KITTITAS COUNTY COMMUNITY DEVELOPMENT SERVICES

April 3, 2019

Subject: Ranch Road Performance Based Cluster Plat (LPF-19-00002) Final Plat. – Staff Review and 2nd Request for Additional Information

RANCH ROAD PERFORMANCE BASED CLUSTER PLAT

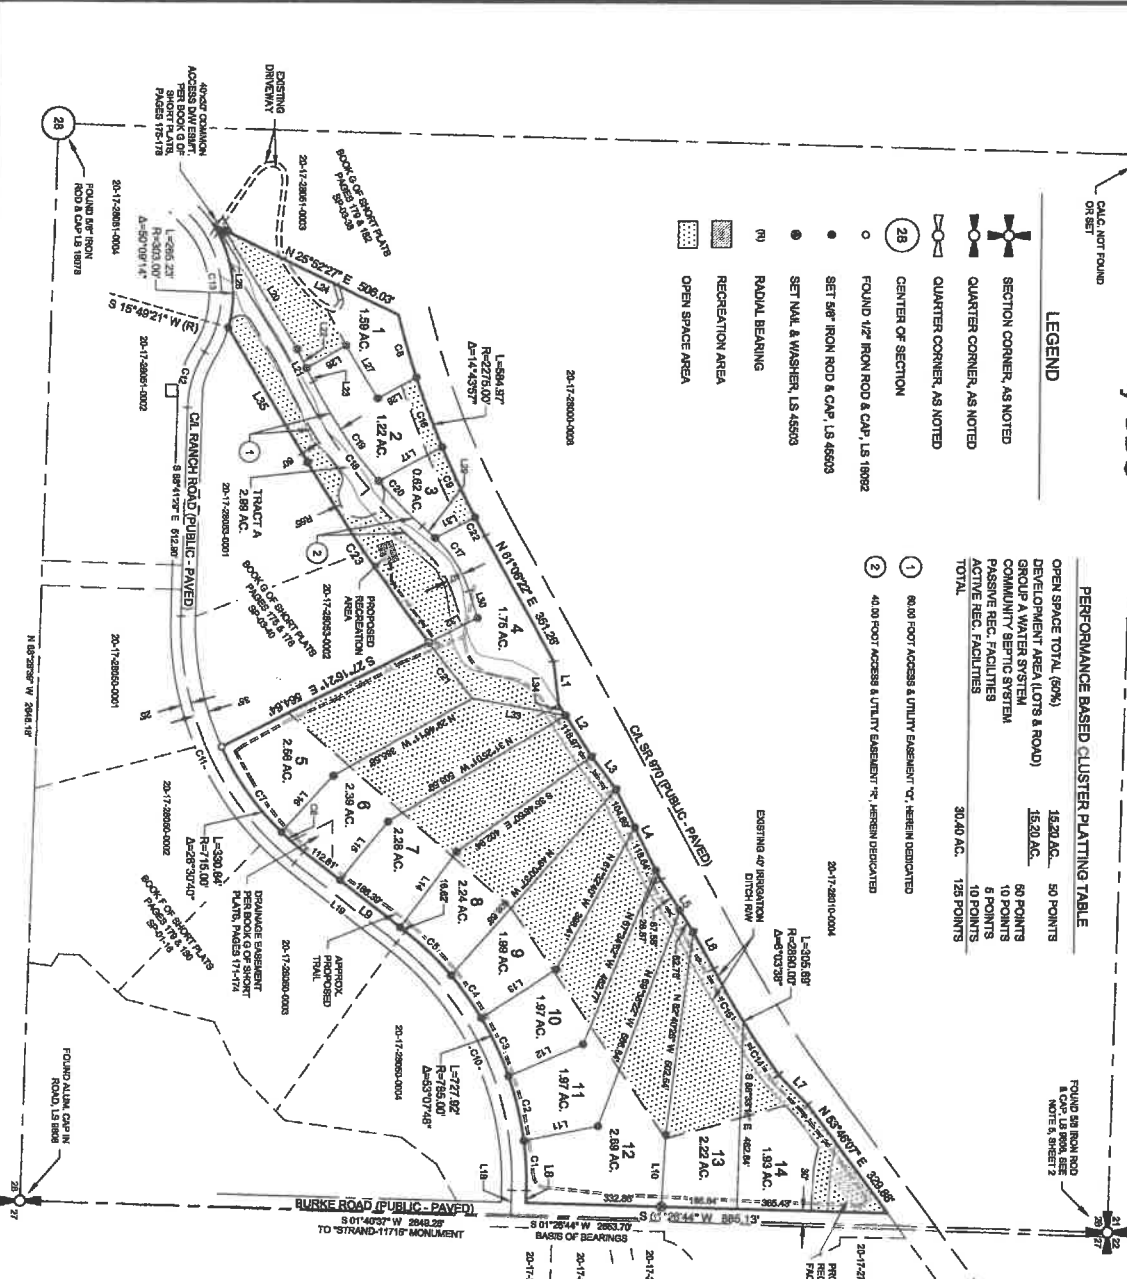
- 1) The requested changes from the previous request for additional information letter dated March 25, 2019 and the Public Works Memo dated March 20, 2019 have all been met except for item 3.
"3. The ownership of public right of way should be clarified as being county or state.
EX: "Burke Rd – County R/W – Paved""

Please provide an updated mylar (sheets that require changes or the licensed surveyor can come to Kittitas County CDS office and hand edit the mylar to reflect the required information) showing all required changes as required by Public Works. Once the requested information has been resubmitted or corrected in person, CDS will route the information to the various departments to review for consistency. As stated above, review, signature, and approval of this plat must occur within 30 days of March 13, 2019. Therefore, this plat must be placed on the April 8th Study Session Agenda (the last board meeting within the 30 day window) for Board decision and signature. With that said, all revised information needs to be submitted to Kittitas County CDS by end of business day **April 4th, 2019** for staff review and signature on the final mylars (this assumes all issues have been addressed adequately
